CITY OF ALBUQUERQUE

Re: Phase II Alteration Level 2
3100 Menaul NE
Traffic Circulation Layout
Architect's Stamp 02-20-20 (H16-D153)

TCL Plan
Scale: 1" = 30'

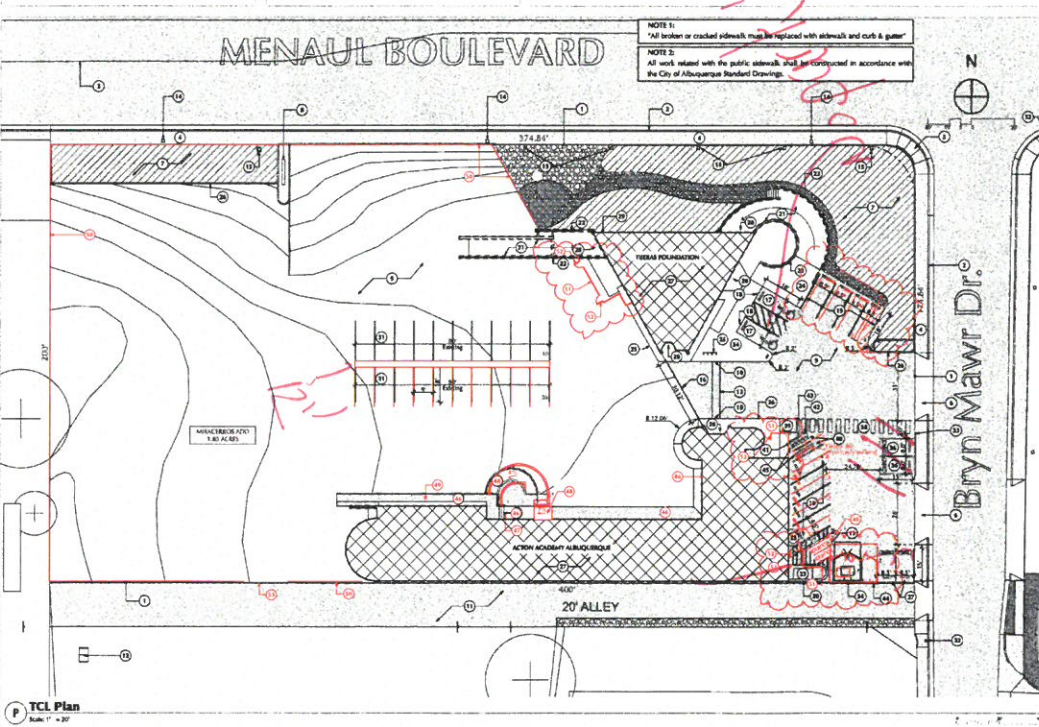
1. The minimum parking stall dimensions are:

Type of parking	Min. Width	Min. Length	Min. Overhang
Standard	8.5'	18'	2'
Compact	7.5'	15'	1.5'
Motorcycle	4'	8'	N/A
ADA	8.5'	18'	2'

2. ADA curb ramps must be updated to current standards and have truncated domes installed (corner of Menaul/Bryn Mawr).
3. Motorcycle parking spaces shall be designated by its own conspicuously posted upright sign, either free-standing or wall mounted per the zoning code.
4. All bicycle racks shall be designed according to the following guidelines:
 - a. The rack shall be a minimum 30 inches tall and 18 inches wide.
 - b. The bicycle frame shall be supported horizontally at two or more places. Comb/toaster racks are not allowed.
 - c. The rack shall be designed to support the bicycle in an upright position. See the IDO for additional information.
 - d. The rack allows varying bicycle frame sizes and styles to be attached.
 - e. The user is not required to lift the bicycle onto the bicycle rack.

- f. Each bicycle parking space is accessible without moving another bicycle.
- 5. A 5 ft. keyway is required for dead-end parking aisles.
- 6. Per the IDO, a 6 ft. wide ADA accessible pedestrian pathway is required from the public sidewalk to the building entrances. Please clearly show this pathway and provide details.

- 7. ADA accessible pedestrian pathway should not be placed behind parking space or adjacent to a vehicular way. Vehicle and pedestrian/wheel chair conflicts should be avoided as much as possible.

- 8. All sidewalk along Menaul specifies two widths dimensions. Please clarify the key notes 4 and 25.
- 9. Curbing should be installed to delineate landscape, parking, and pedestrian ways and identify points of access. Please call out detail and location of barrier curb along segment of 20 ft. Alley, new trash enclosure, and proposed compact parking spaces(2).

- 10. Parking areas shall have barriers to prevent vehicles from extending over public sidewalk, public right-of-way, or abutting lots. Please verify the compact parking spaces (2) fronting Bryn Mawr.

- 11. Please specify the City Standard Drawing Number when applicable.
- 12. Unused curb cuts must be replaced with sidewalk and curb & gutter(2 unused driveways shown off Bryn Mawr). A build note must be provided referring to the appropriate City Standard drawing.

- 13. Add a note stating "All broken or cracked sidewalk must be replaced with sidewalk and curb & gutter." A build note must be provided referring to the appropriate City Standard drawing.

- 14. Provide more detail, on sheet C-501 (Detail C,O and T) and sheet C-102(Key Note 43), to ensure that proposed pedestrian path connection onto existing sidewalk is ADA accessible.

- 15. Key Notes 10, 33 and 42 will need details.
